Section 55: Acceptance of Applications

A303 Sparkford to Ilchester Dualling: Section 55 Application Checklist¹

A303 SPARKFORD TO ILCHESTER DUALLING
WORKS PLANS REGULATION 5(2)(J)
SHEET 1 OF 4

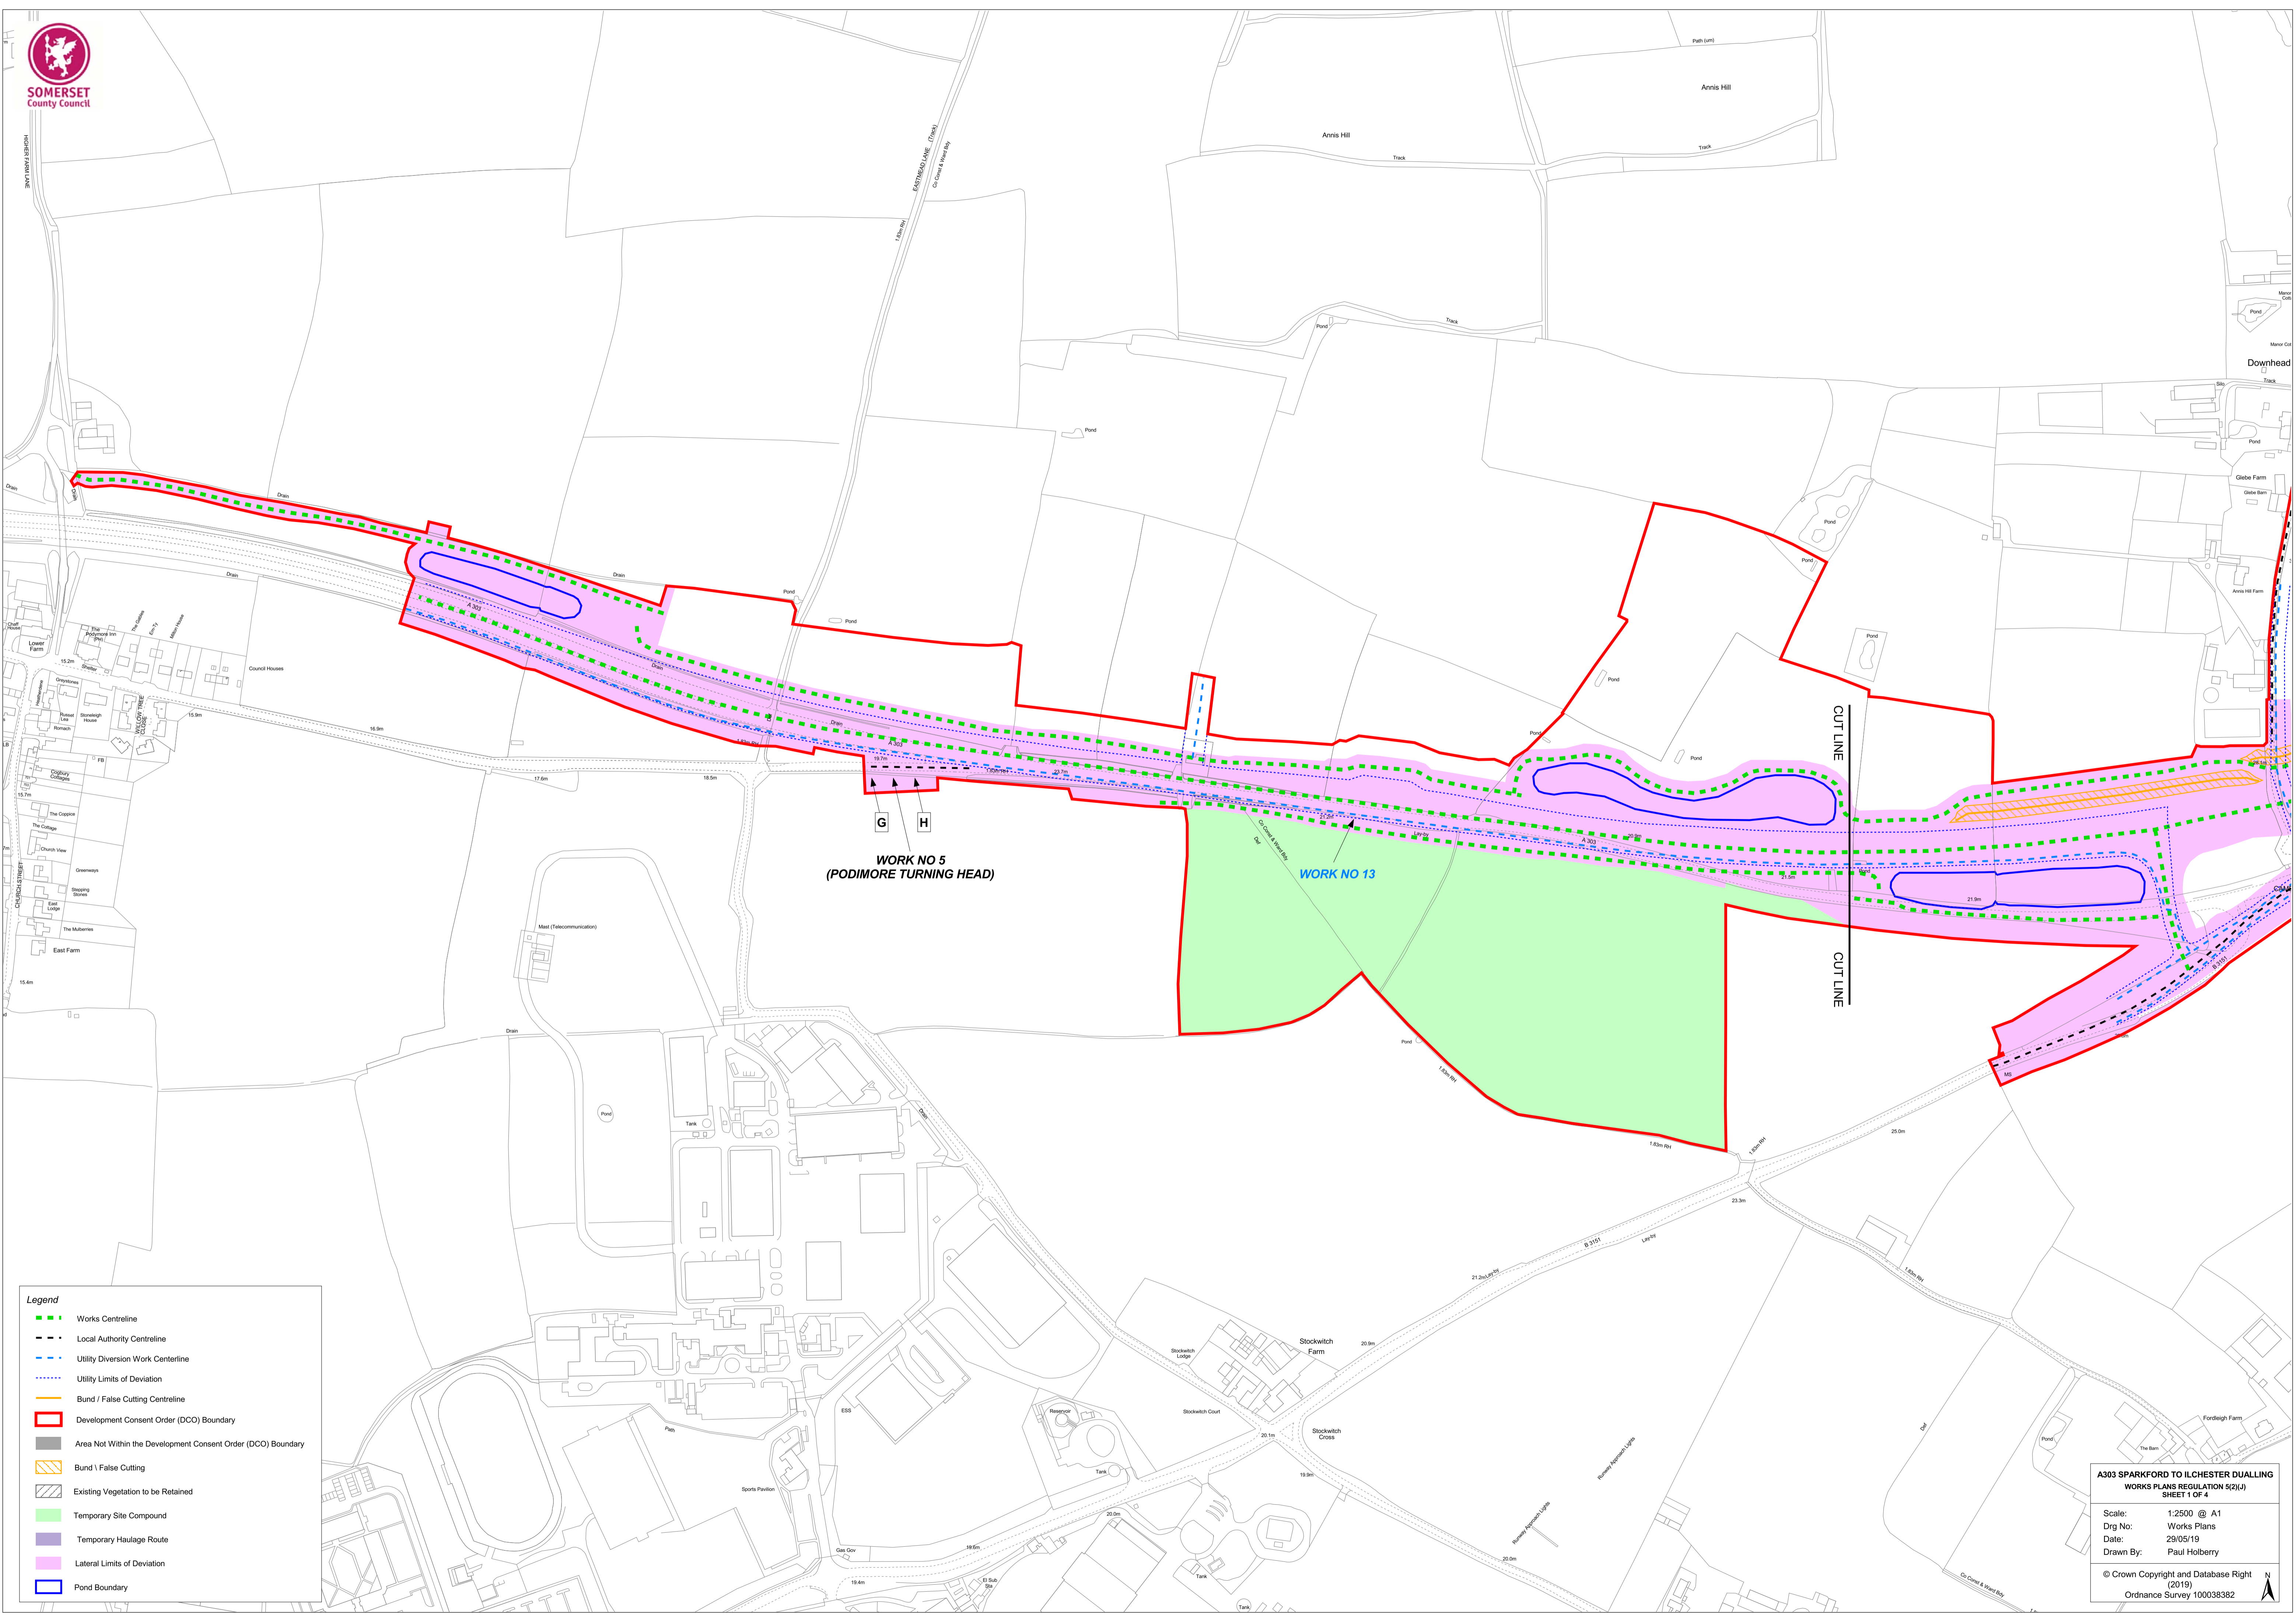
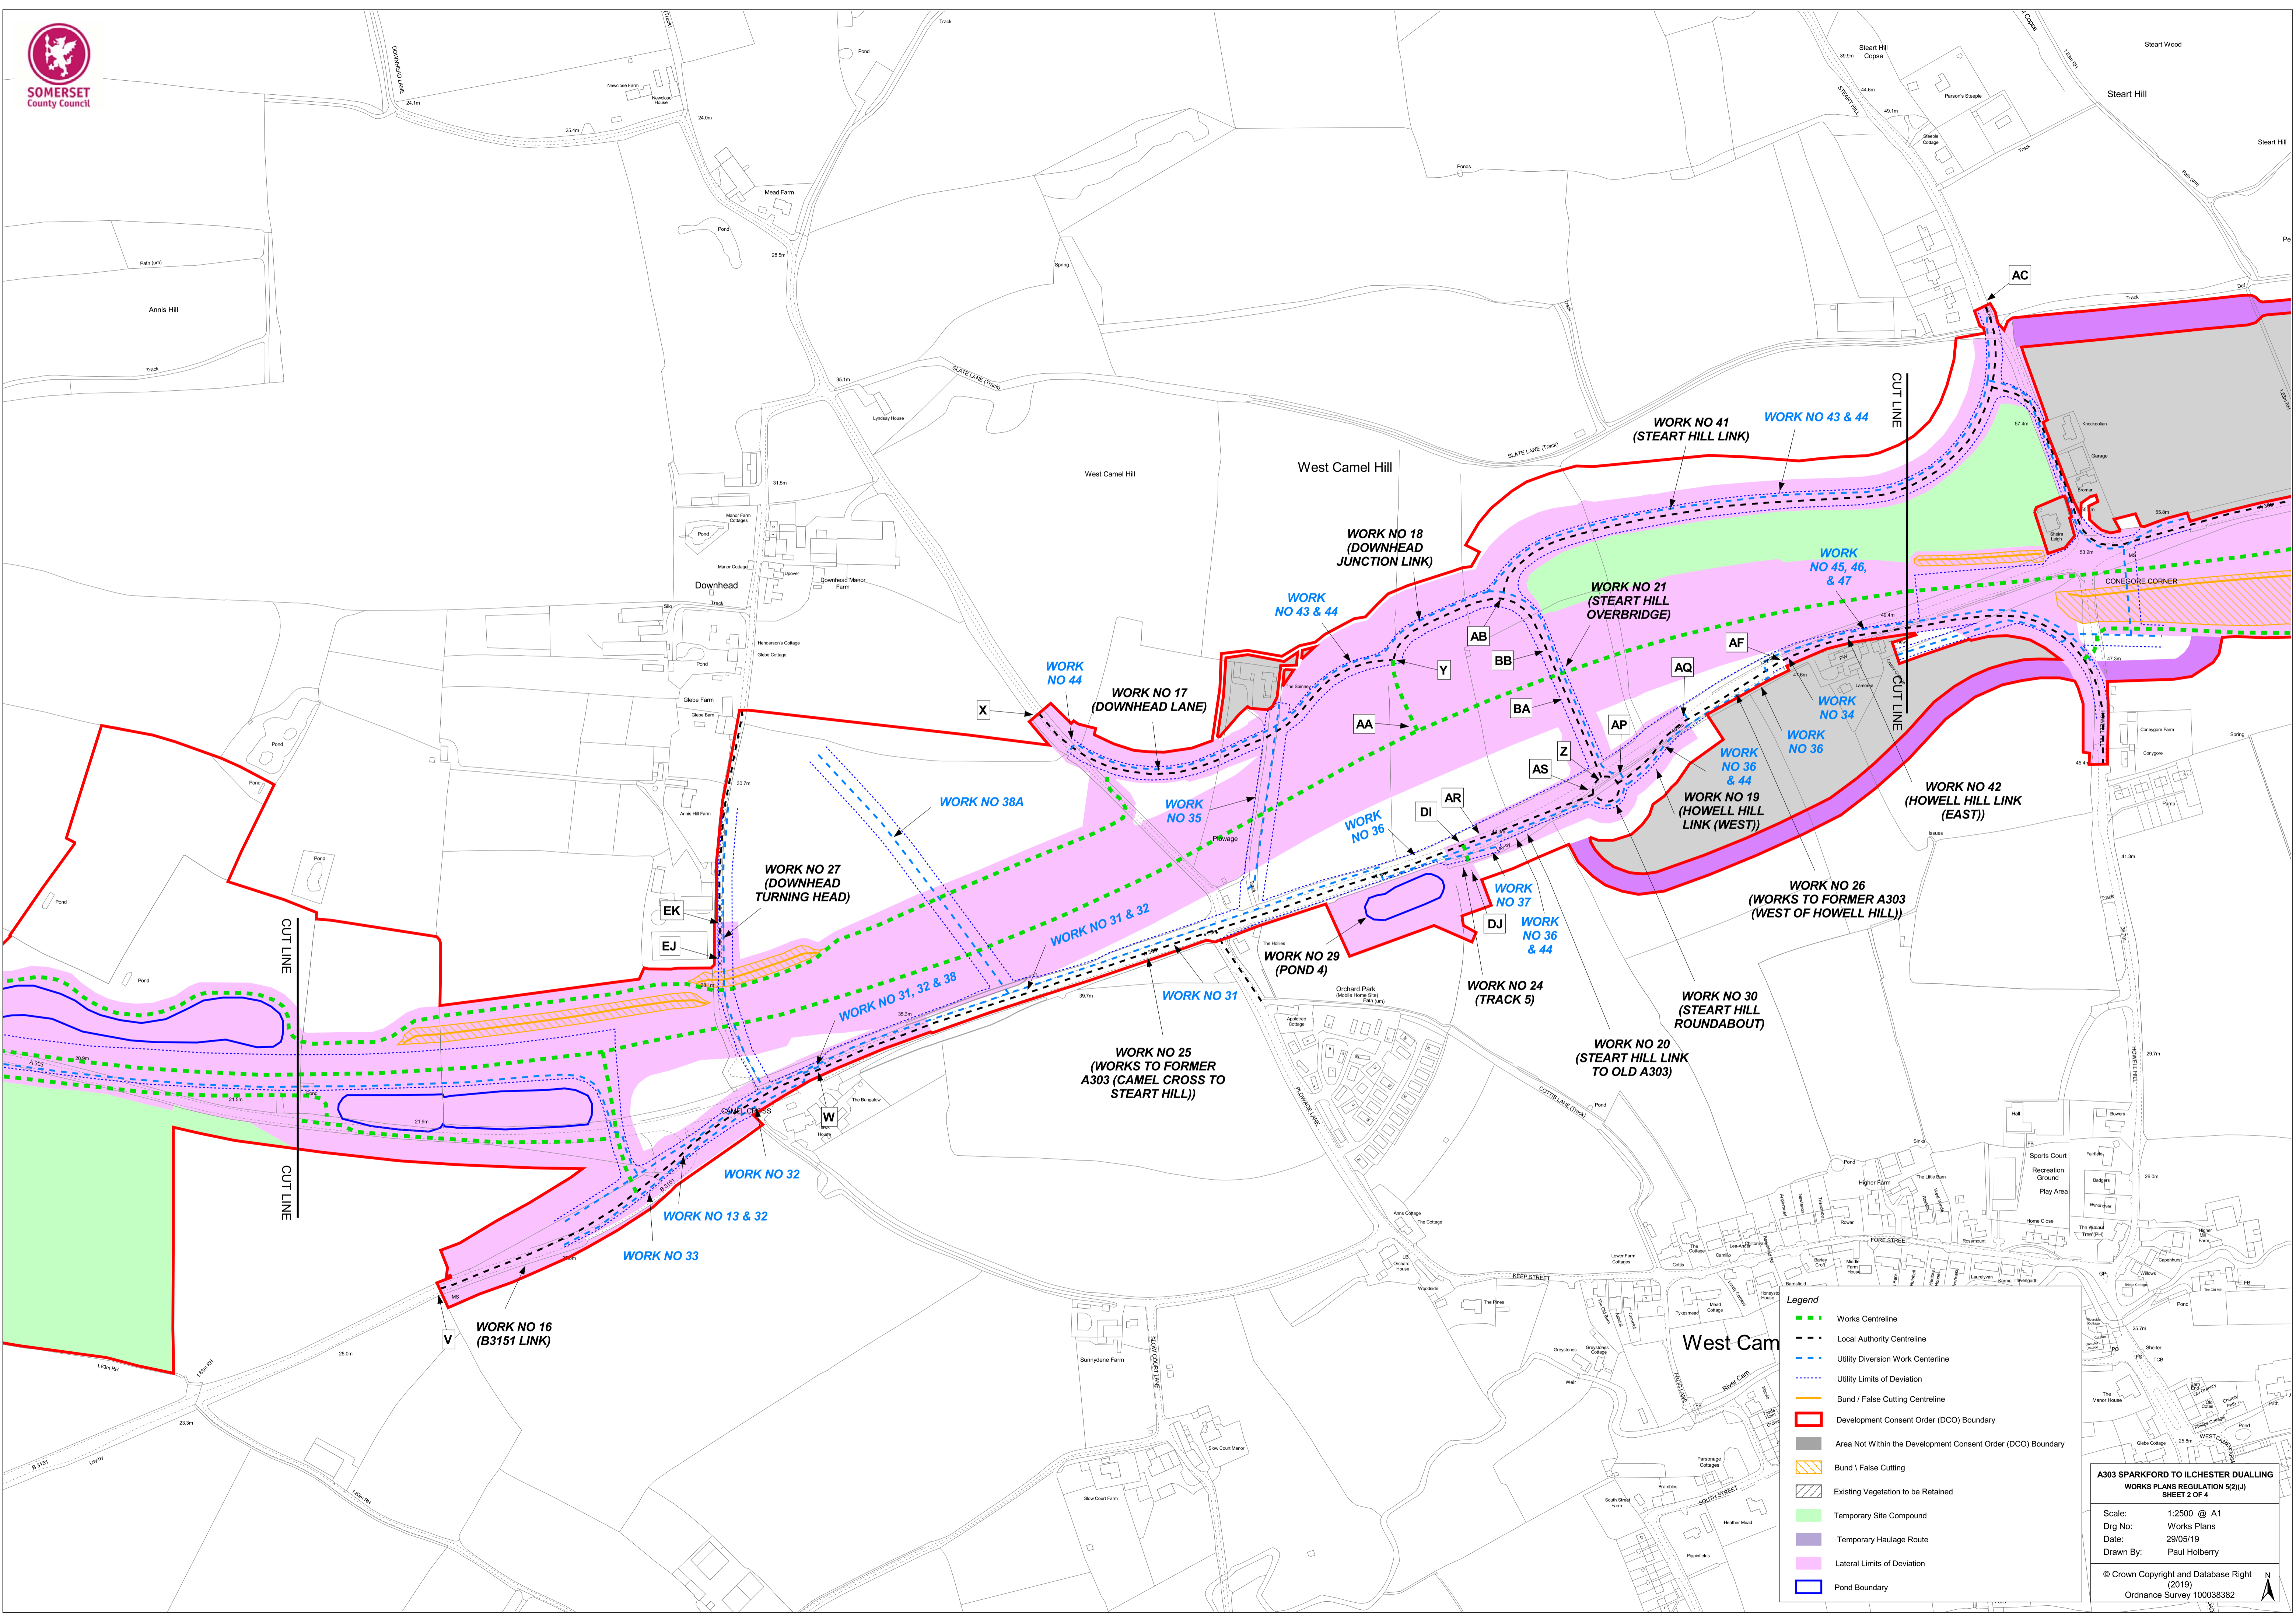
Work No.12 in **Schedule 1** of the **Draft Development Consent Order (Document 3.1)** refers to point 'DE'. This point is not marked on the relevant **Works Plan (Document 2.3)**. Similarly Work No. 61 refers to point 'EE' and this point is not marked on the relevant Work Plan.

Work No.10 in **Schedule 1** of the **Draft Development Consent Order (Document 3.1)** refers to an Ecological mitigation area. The limits of deviation for this work are not marked on the relevant **Works Plan (Document 2.3)**.

Work Nos. 43 and 44 in **Schedule 1** of the **Draft Development Consent Order (Document 3.1)** refer to point 'KA' shown on sheets 2 and 3. Whilst 'KA' and 'KQ' are marked on sheet 2 the same point is recorded as 'AC' on sheet 3. Similarly Work No. 75 refers to point 'KQ' on sheet 3. This point is only marked on sheet 2 and the same point is recorded as 'AD' on sheet 3.

Work No.56 in **Schedule 1** of the **Draft Development Consent Order (Document 3.1)** is described as shown on sheet 3, however sheet 4 also gives a location for Work No. 56 and describes this as "WORKS TO FORMER A303 WEST OF HAZELGROVE ROUNDABOUT".

Work No. 68 in **Schedule 1** of the **Draft Development Consent Order (Document 3.1)** is described as shown on sheet 3 between points 'EA' and 'AH'. The Work on the relevant **Works Plan (Document 2.3)** does not point to this location.

Section 51 advice has been issued regarding this matter: <https://infrastructure.planninginspectorate.gov.uk/document/TR010036-000268/>. The
